From: Richard Dollamore [REDACTED]
Sent: 24 January 2020 14:08
To: Simon Davis <Simon.Davis@arun.gov.uk>
Cc: 'Gareth Giles' [REDACTED]
Subject: RE: Inglenook P/58/19/PL
Importance: High

Subject: RE: Inglenook P/58/19/PL

2017-3763-002

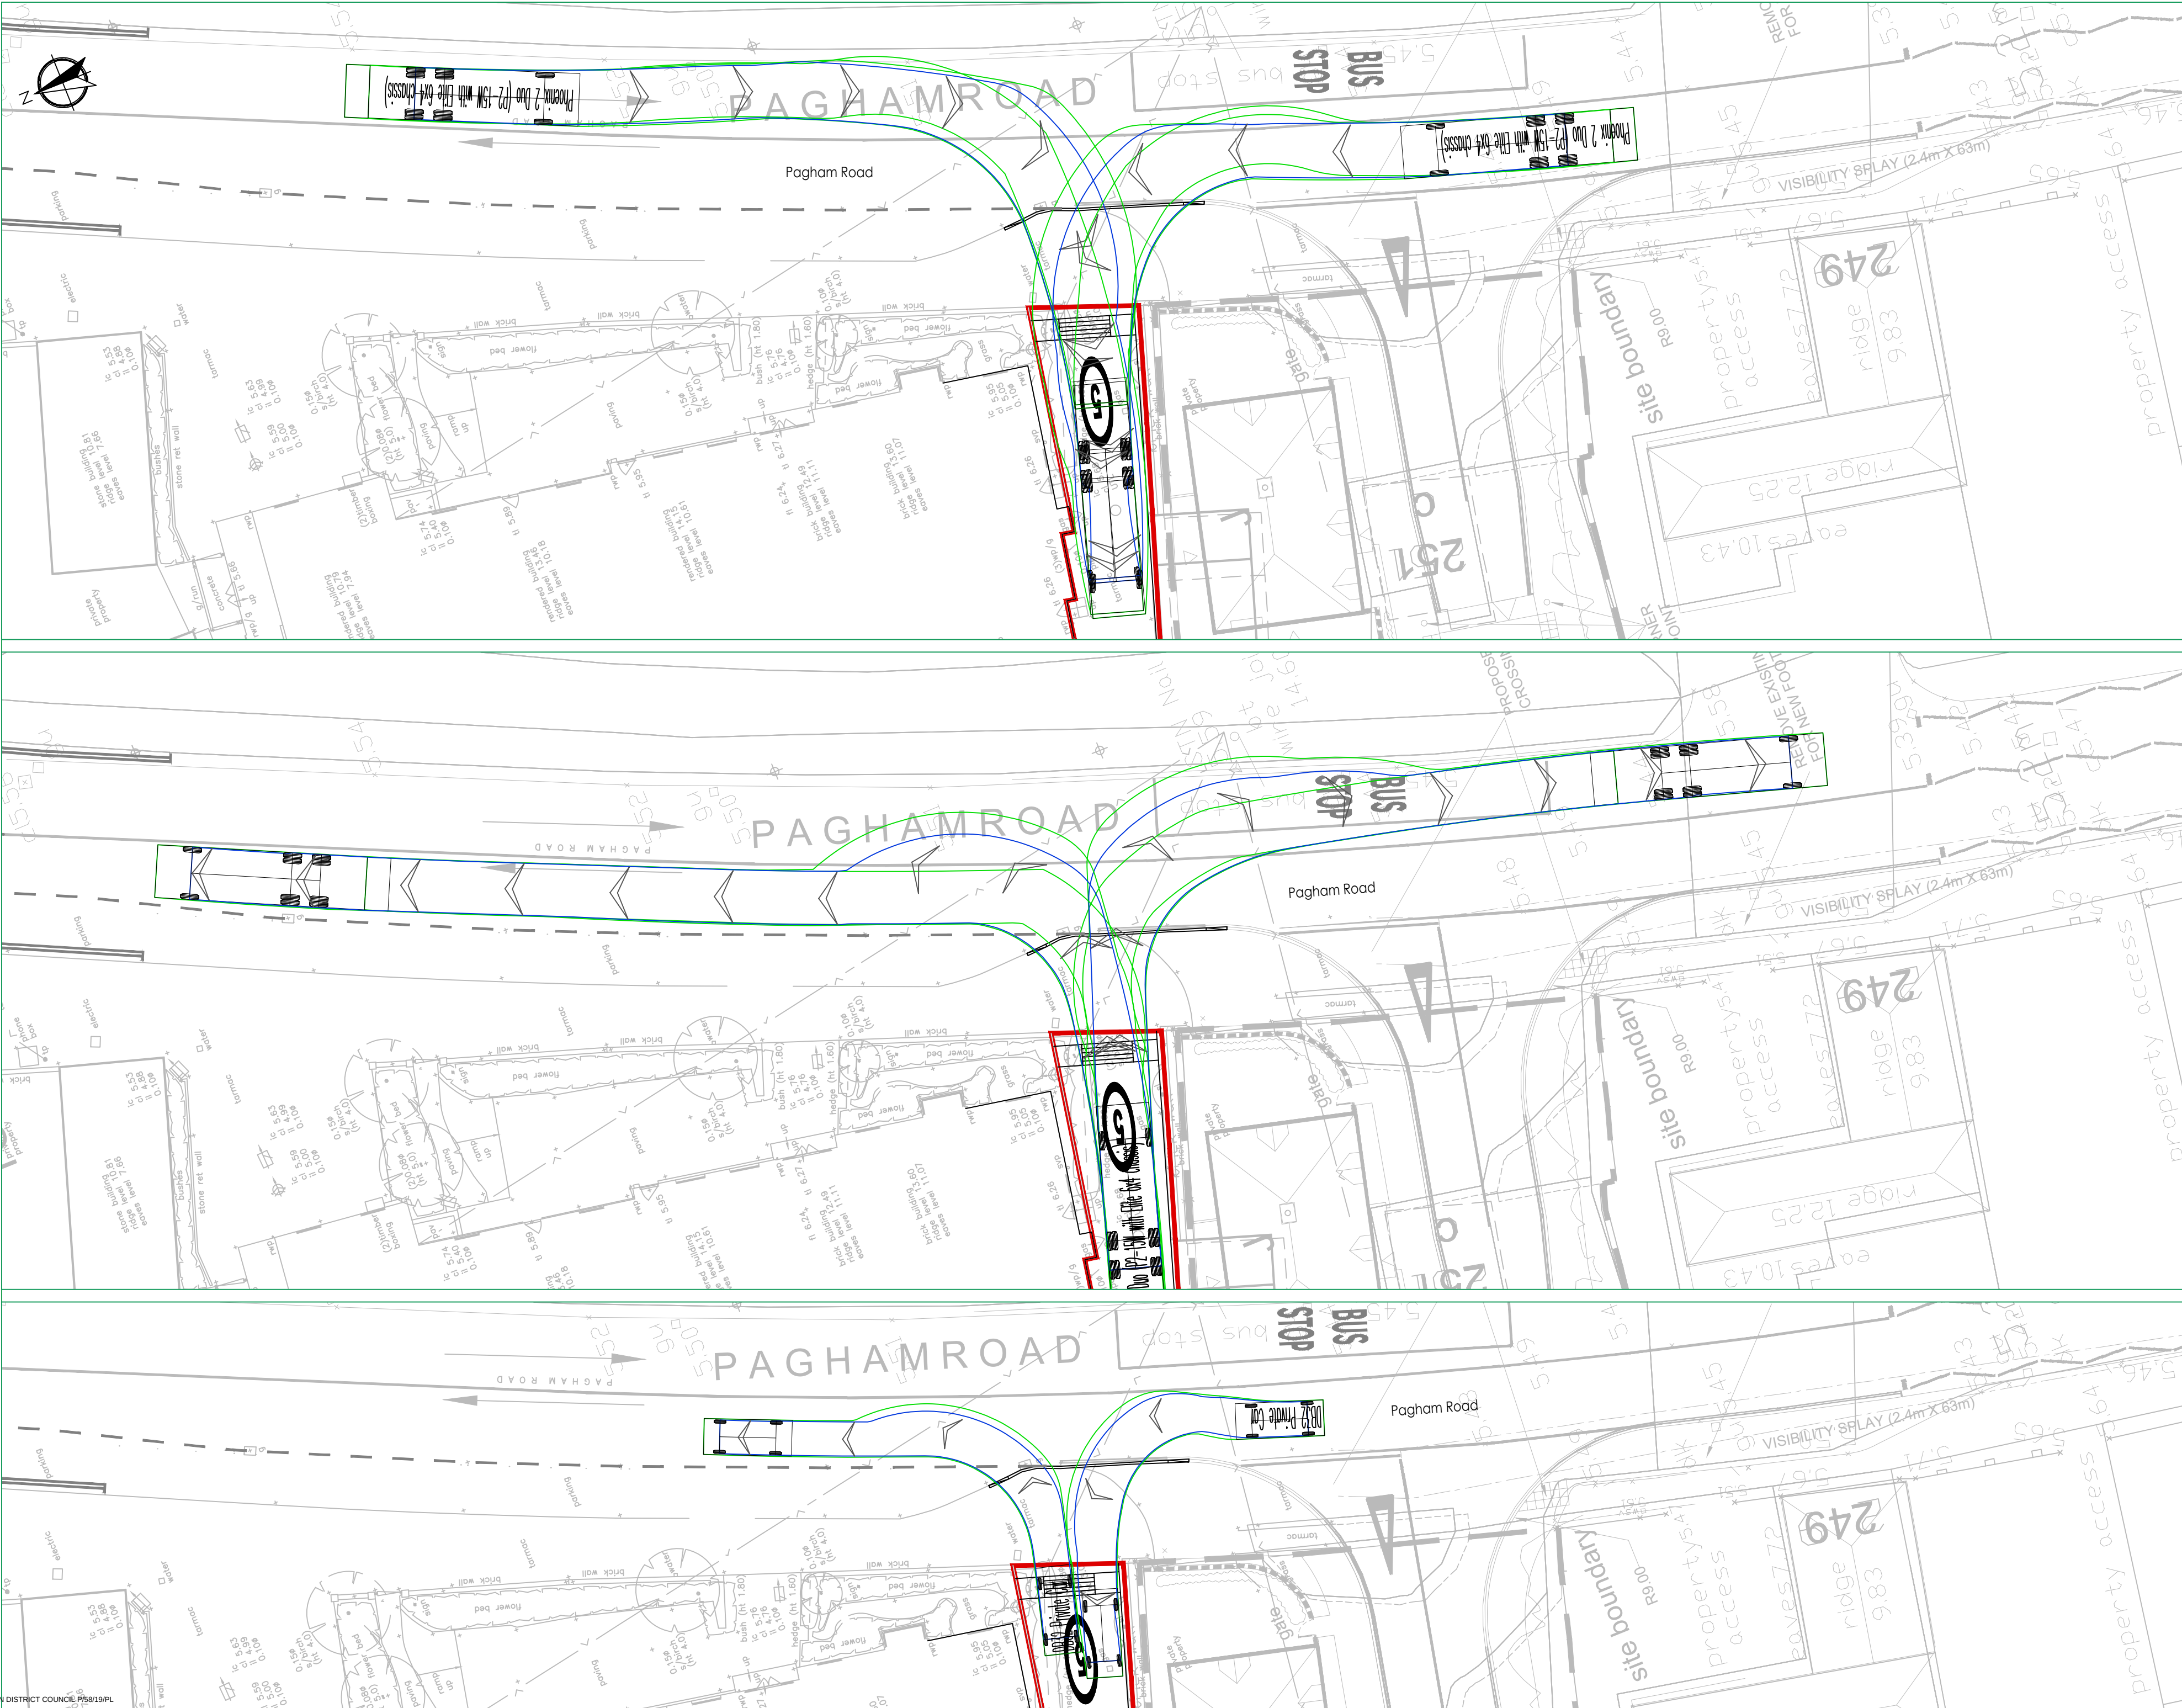
- *Manual For Streets (MfS) does suggest that occasional parking in visibility splays is quite common but defined bays should be provided outside visibility splays. The presence of the layby to the north will have a significant impact to the safety with the additional flow expected from the development at peak times.*
Manual for Streets suggests (paragraph 7.8.5) that such incidences of parking in visibility splays do not create issues in practice. The access and layby are longstanding and operate without issue, including in terms of visibility for drivers. The accident records demonstrate that there are no existing safety issues in this locality and the access and its associated visibility splays do not therefore create any issues in-practice. The additional impact of the development traffic would be minimal and, in any event, would be more than offset by the access improvements that would be delivered as part of the scheme. The Wilbar report also confirms at paragraph 5.2.3 that the impact of the development is unlikely to have a detrimental impact to the transport network in the vicinity of the site.

- *The swept path analysis of the narrowest part of the access road is very close to lamp columns and steps with no margin of error –*
The lamp columns would be removed as part of the scheme.
- *It seems poor planning to construct two separate access roads adjacent to each other when one could serve the same purpose and reduce the impact on Pagham Road and the safety concerns raised. –*
As with any planning application, the proposed scheme should be considered on the basis of the plans presented, which have been demonstrated to be suitable in highway and transport terms, notwithstanding any alternative access arrangement that may or may not be achievable.
